Objection letter  
391 St Albans Road West

MRS GLORIA ROWLAND
Home Extension
391 St Albans Road West, Hatfield, AL10 9RU
Existing Gound, First
Second & Roof Plan

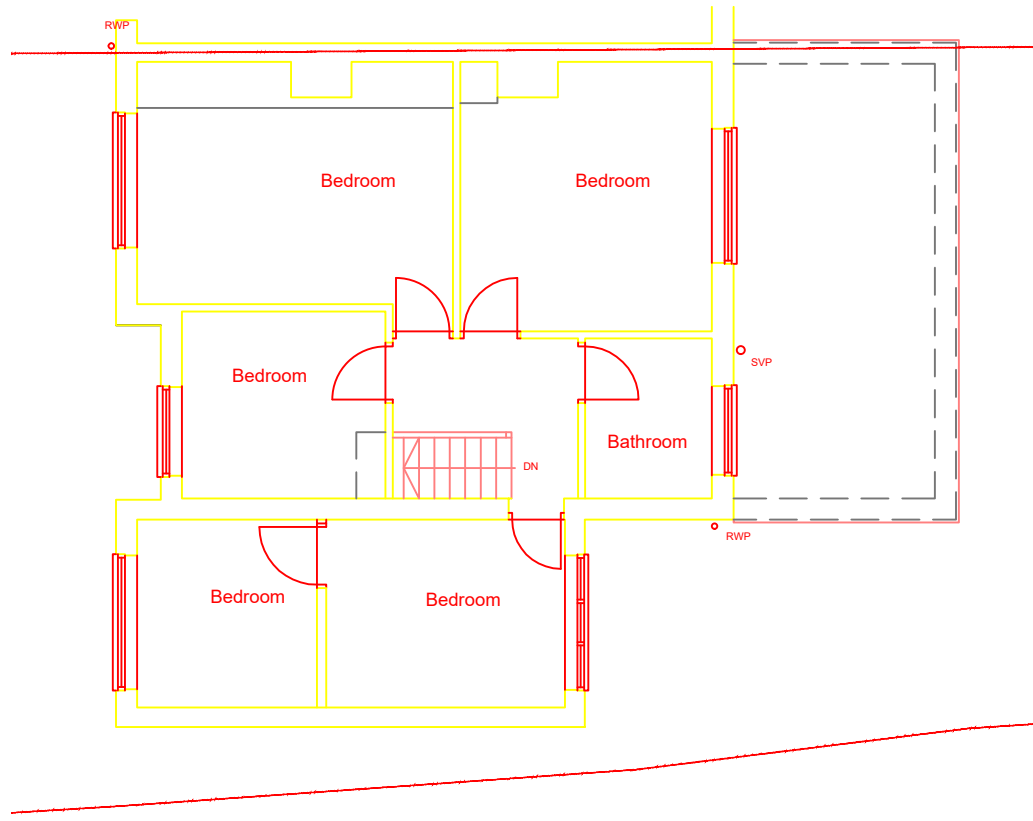
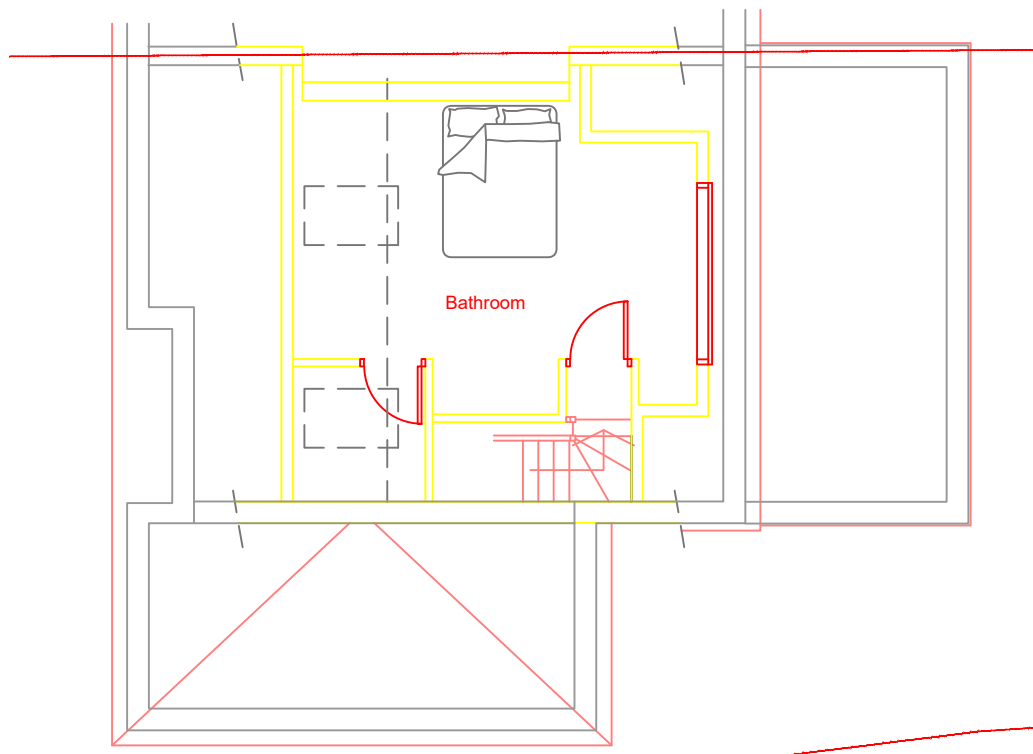
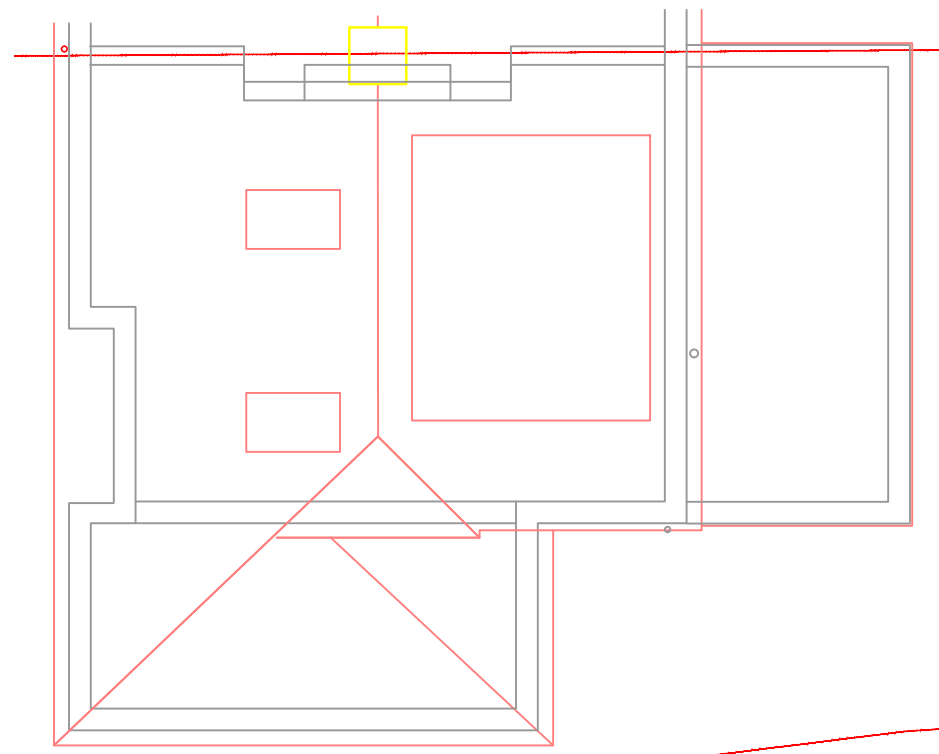
Looking at the supplied plans the existing property doesn't not match the situation on site. Room seems to be missing that is present above kitchen area and dormer is showing with windows facing the front of the property which is not present either.

MRS GLORIA ROWLAND  
Home Extension  
391 St Albans Road West, Hatfield, AL10 9RU  
Existing Shed 01  
Ground Floor & Roof Plan  
Elevations

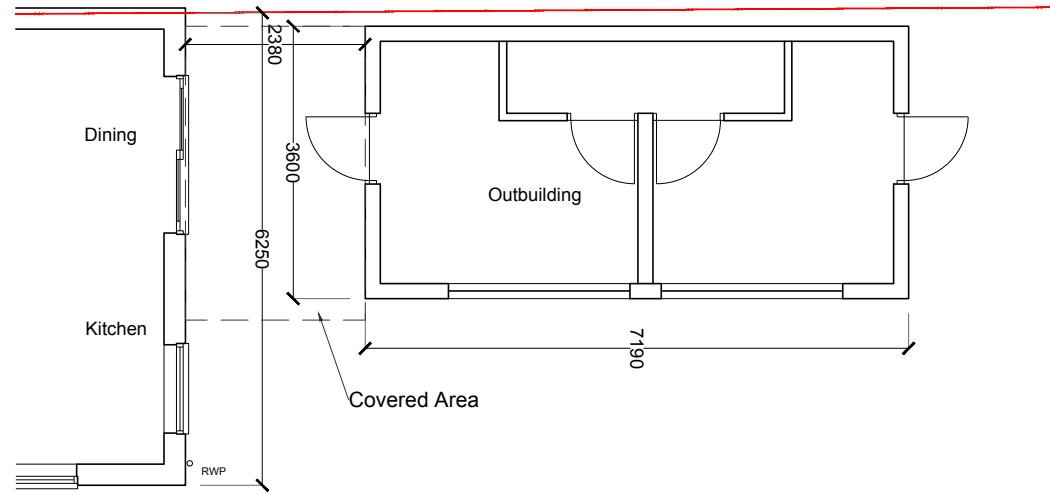
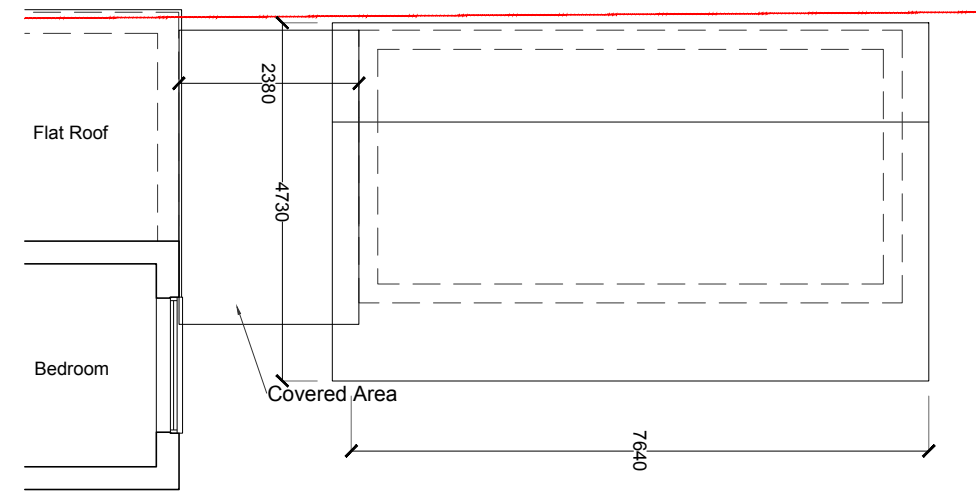
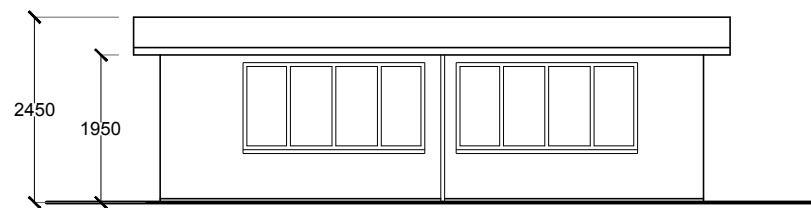
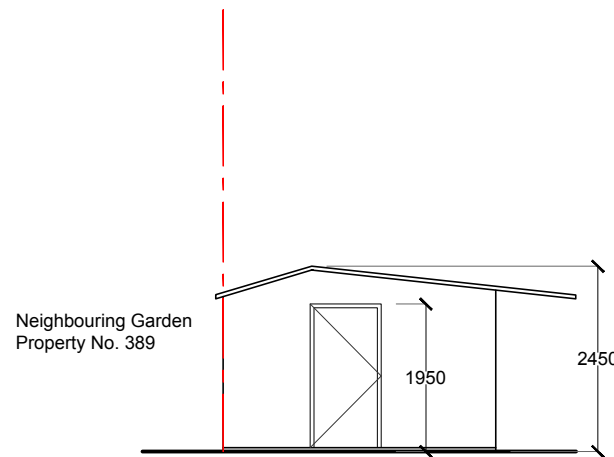
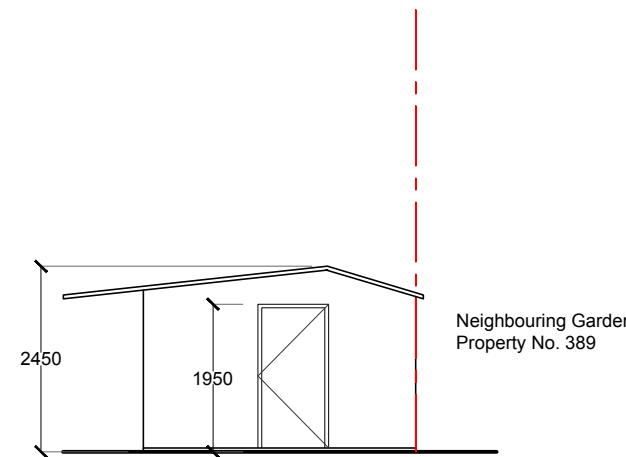
Outbuilding way bigger than what was granted in the previous plans (games room) with rules of use attached in a document. Outbuilding too close to main dwelling. If ground floor gets extended will practically connect the unlawful outbuilding with the main house. This should be well inspected prior to any decisions are made on this application.
